5. Landscape & Visual Steeple Renewables Project

November 2025

**FIELDS FOR
FARMING**

DRAWING NUMBER

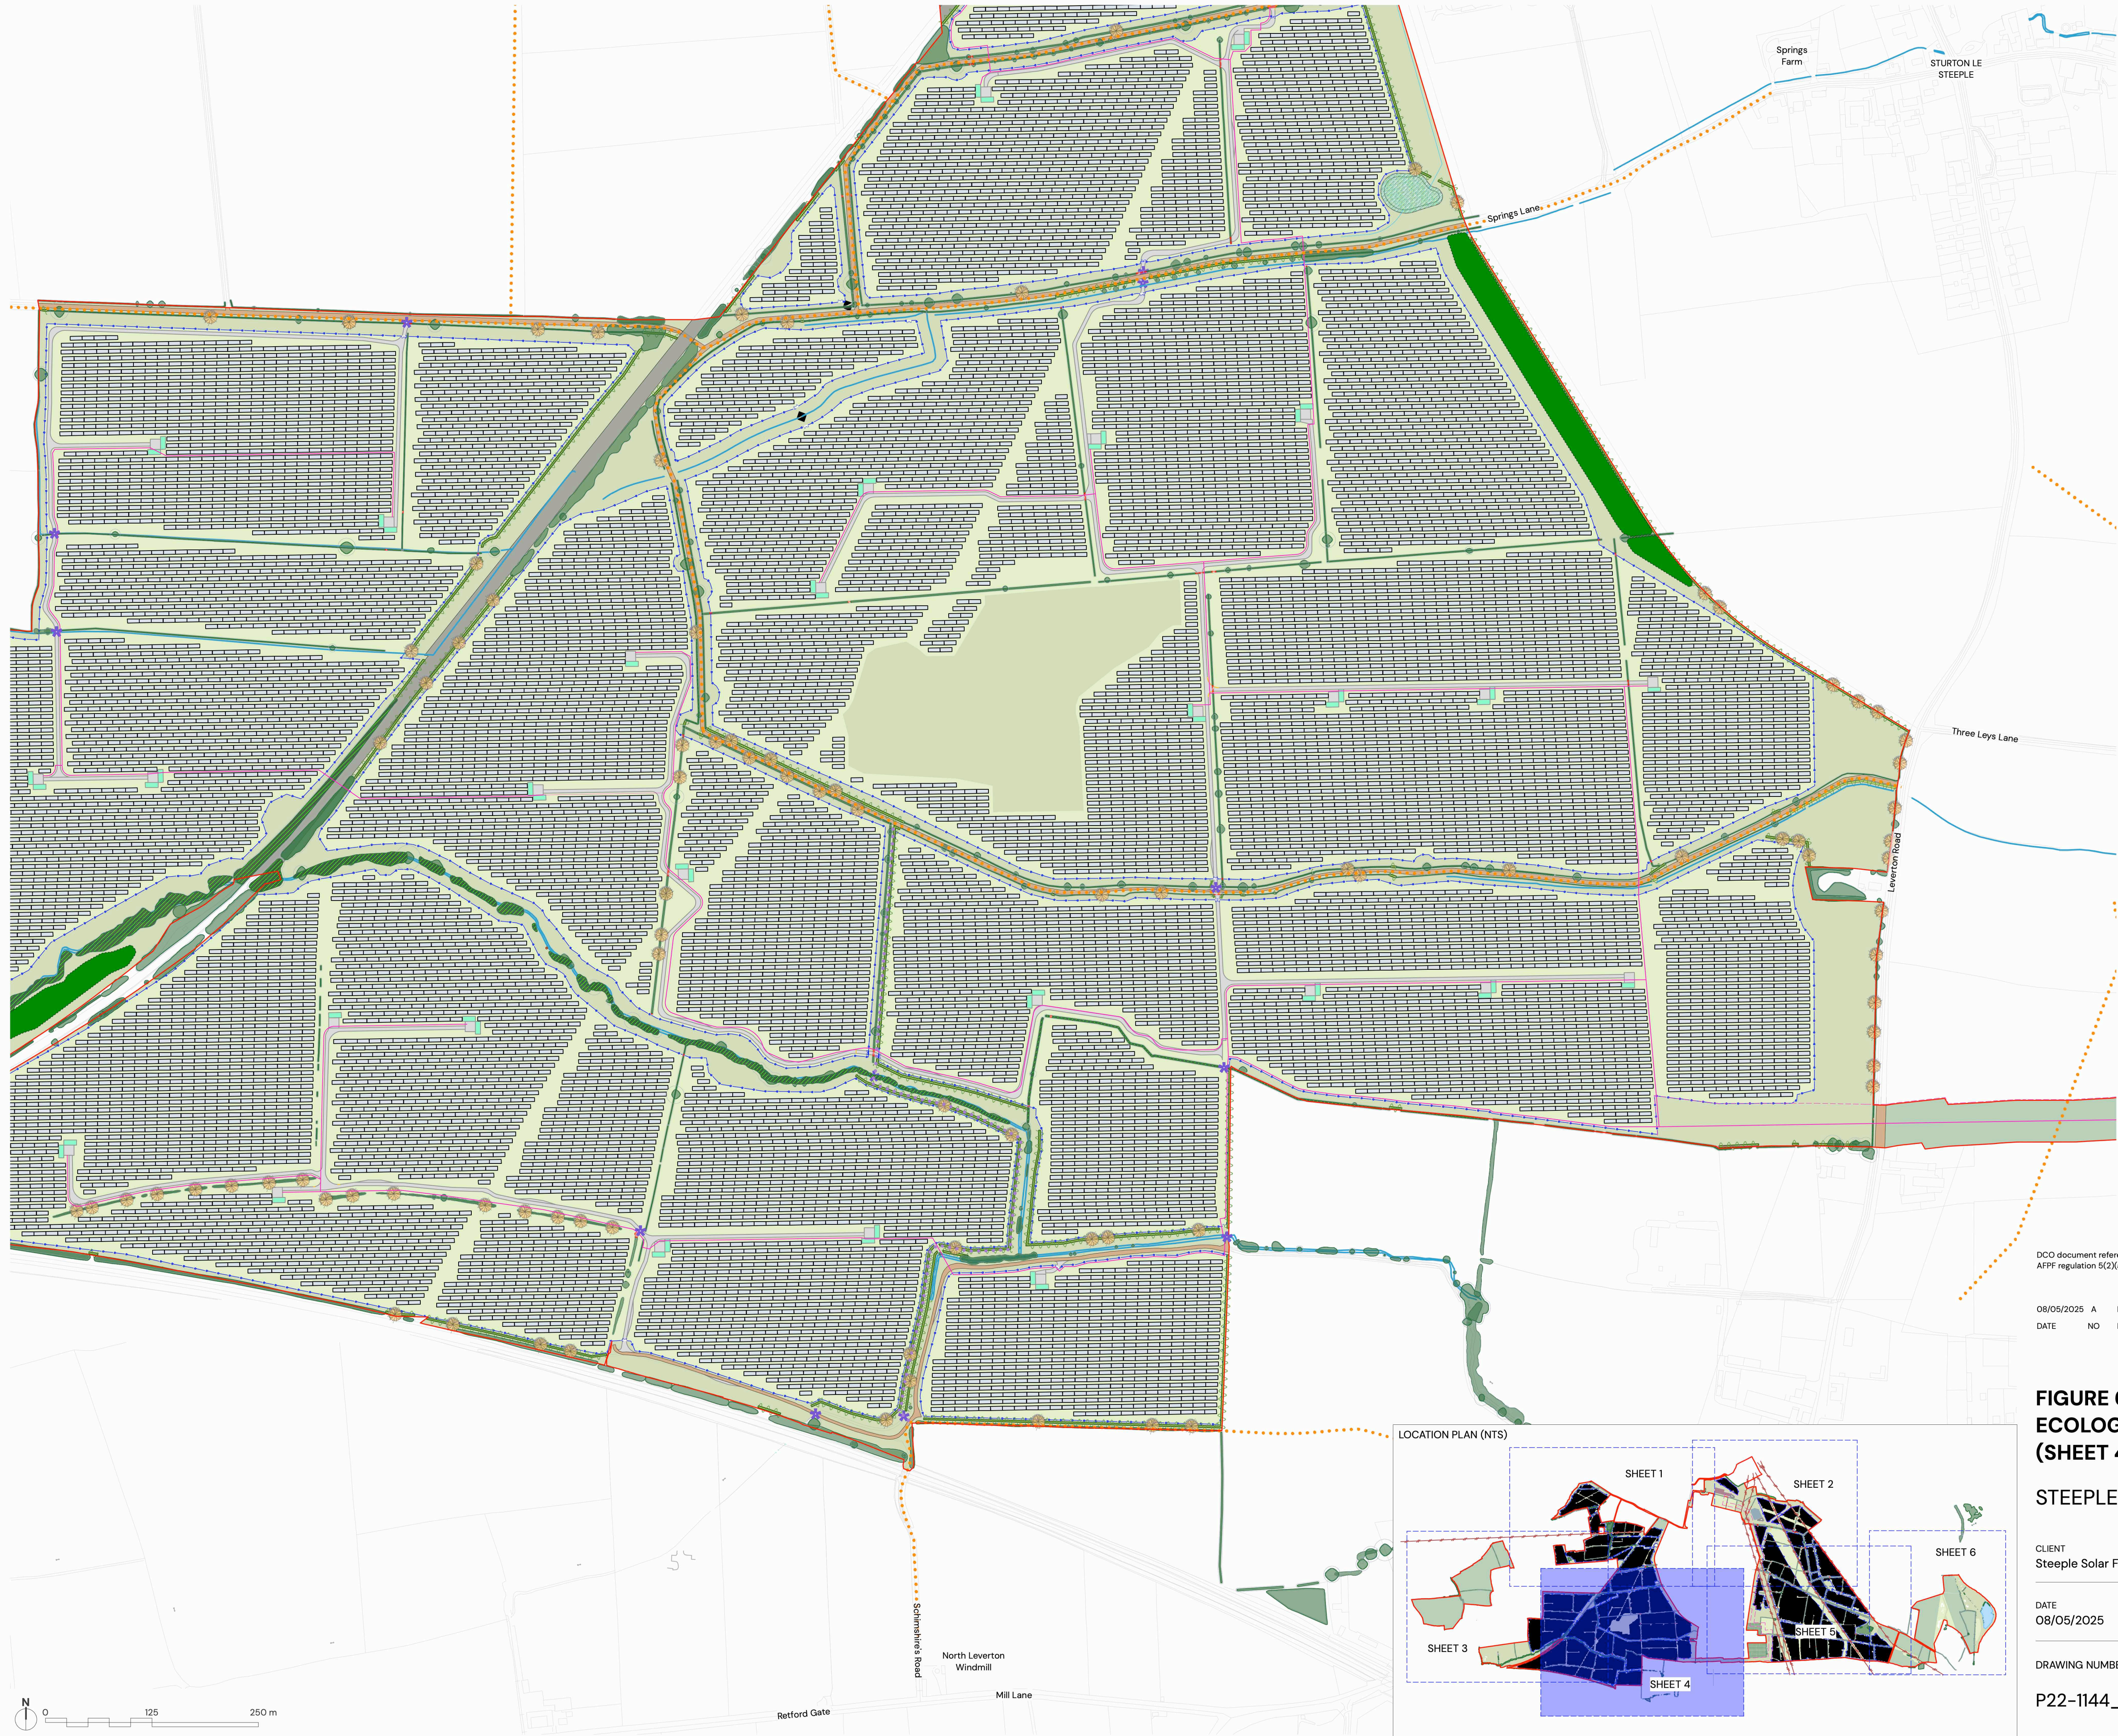
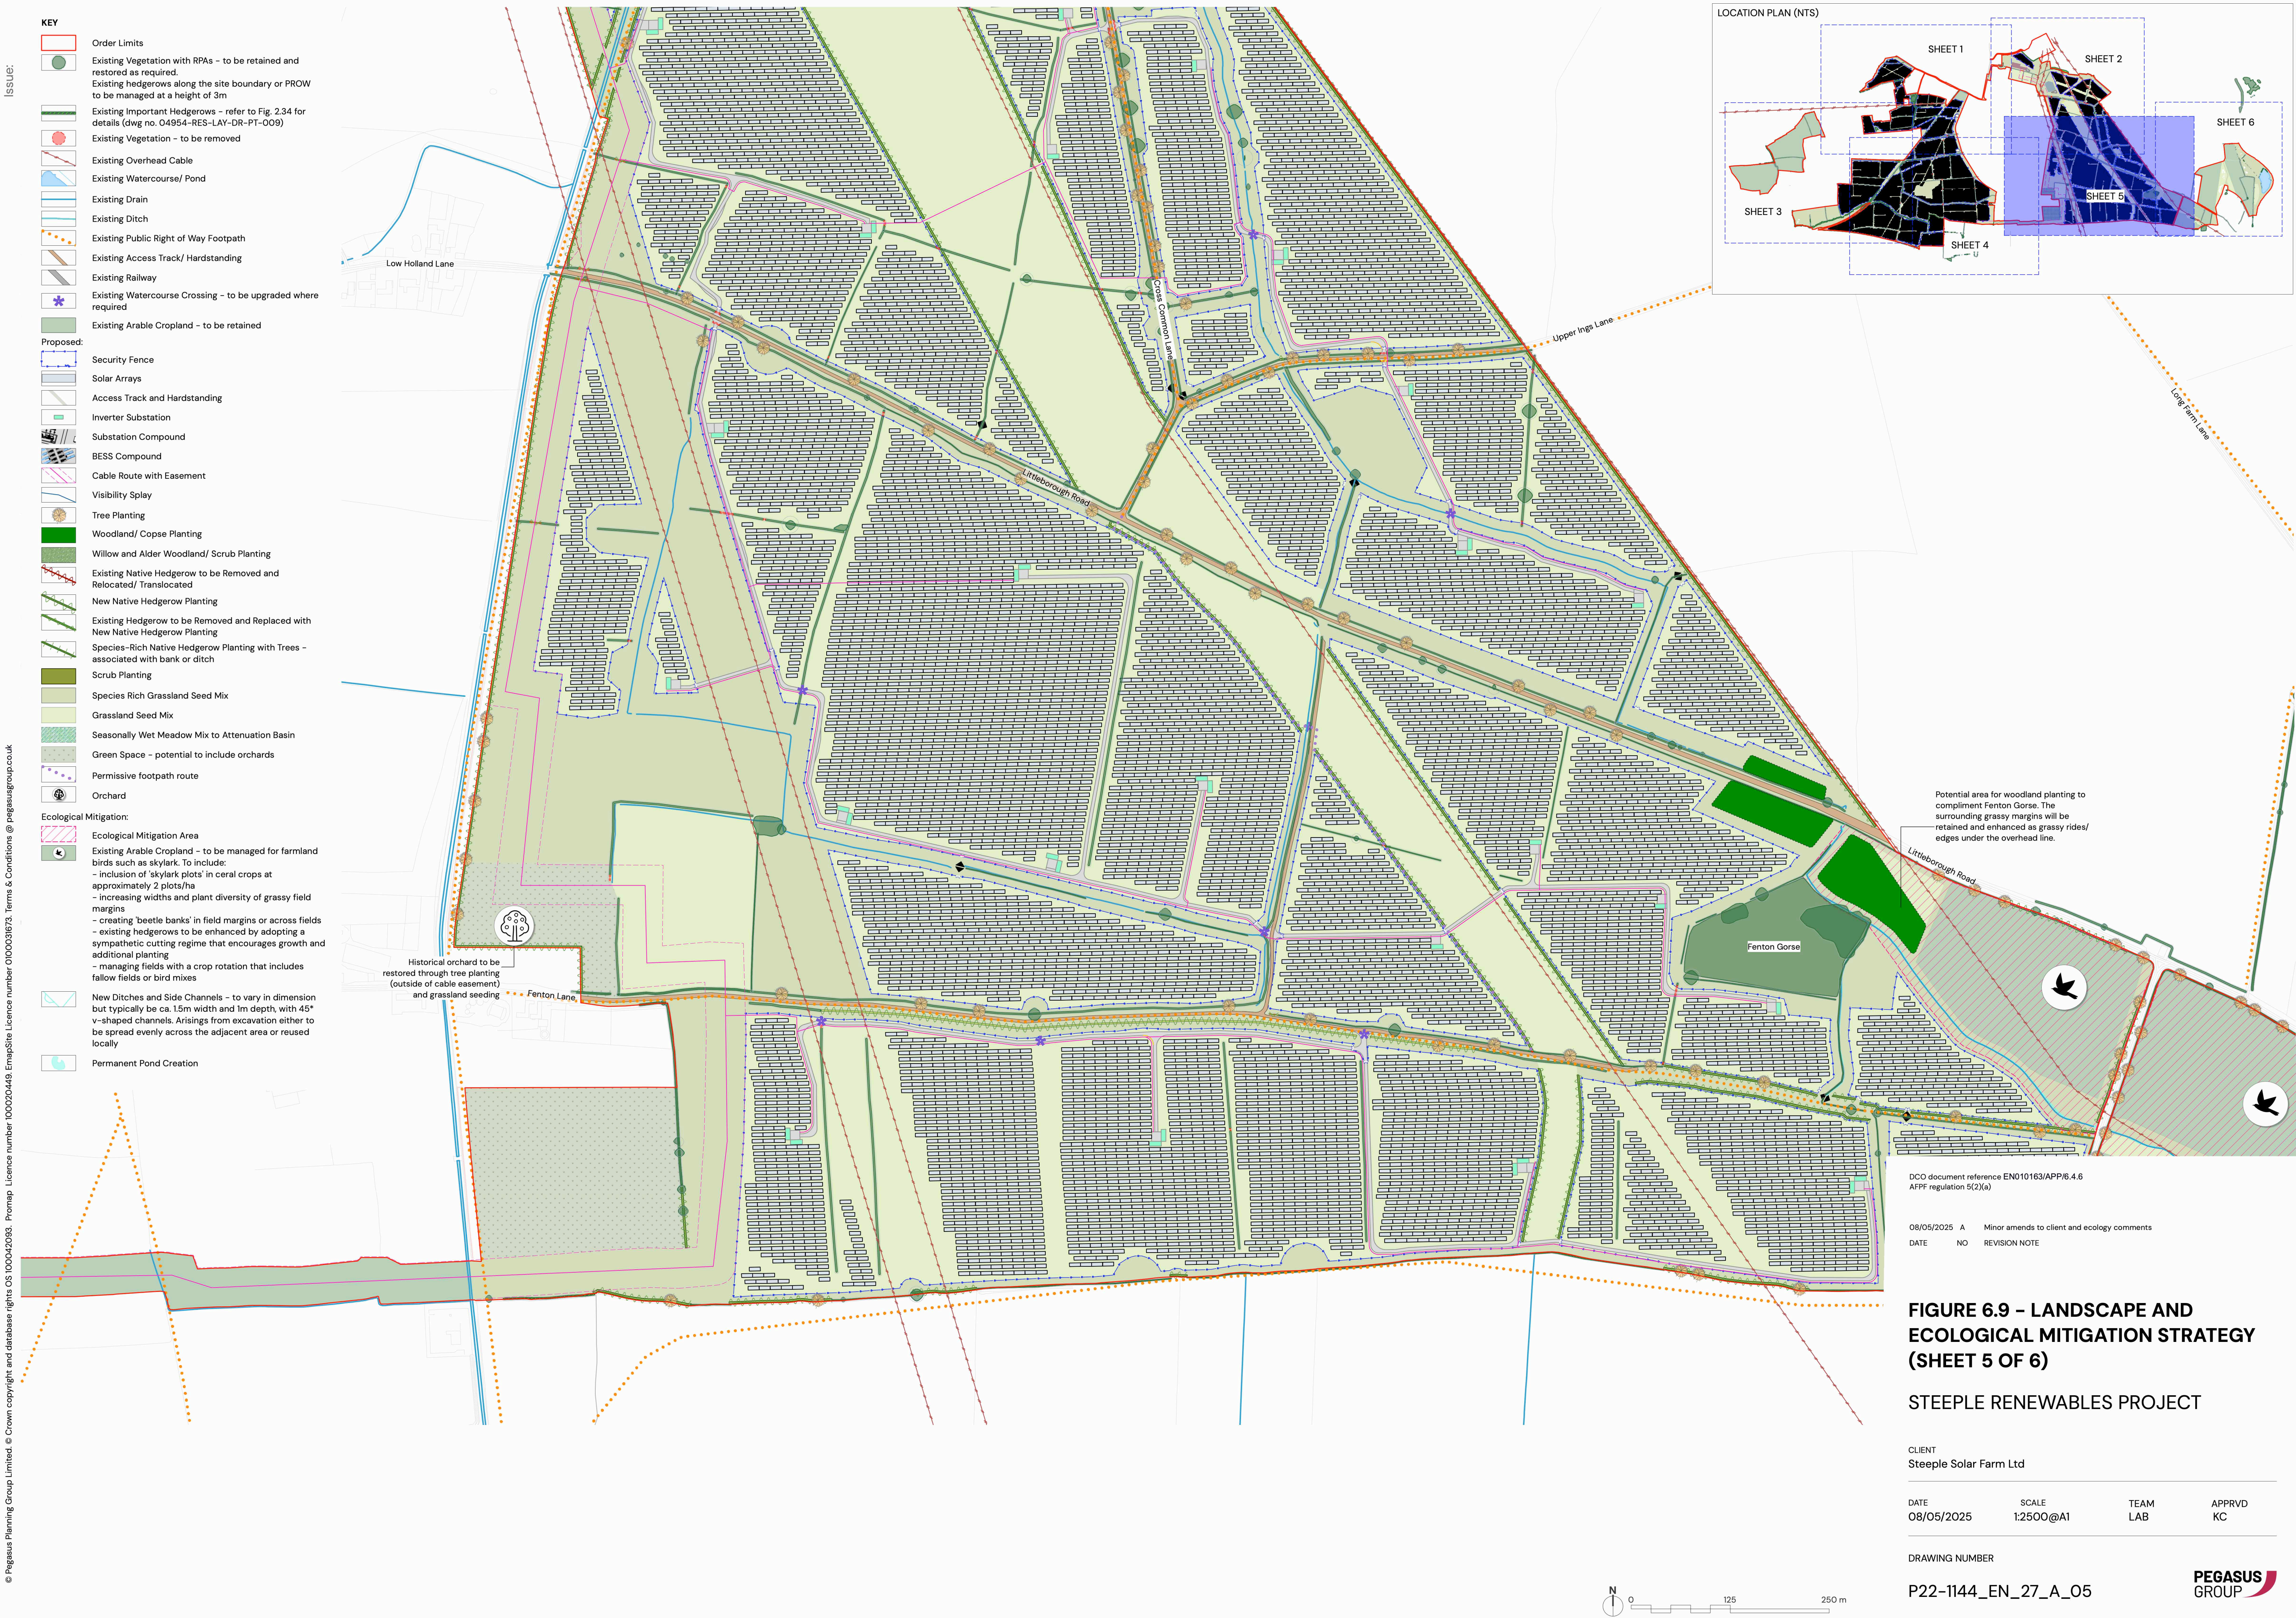
Numerous Public Rights of Way (PROW) and permissive paths intersect the Site and are shown on Figure 6.9 Outline Landscape Mitigation Strategy [EN010163/APP/6.4.6]. The maintenance of these has been considered in relation to their influence on habitat condition, for example greater hedgerow cutting frequencies may be needed adjacent to PROW, but management prescriptions for the PROW have not been specified, as they do not have their own ecological objectives.

It is difficult to determine from the above whether the hedgerows bordering the PROW will be managed or not or indeed in what manner which has an impact on visual assessment outcomes, and how their impact on NBG can be assessed if the management of them is not determined.

The applicant confirmed they intend to plant/allow existing hedgerows to grow either side of Trent Valley Way and other PROWs. These hedges will be allowed to grow to 3m high, and it is not clear how often these hedgerows will be maintained. The applicant claims this will still afford pleasant and open views. This is simply not true, the proposed 15m wide routes with 3m hedges will not feel "open and pleasant" in a rural landscape; they create a confined, engineered corridor that fundamentally changes the character of the Trent Valley Way and public right of way.
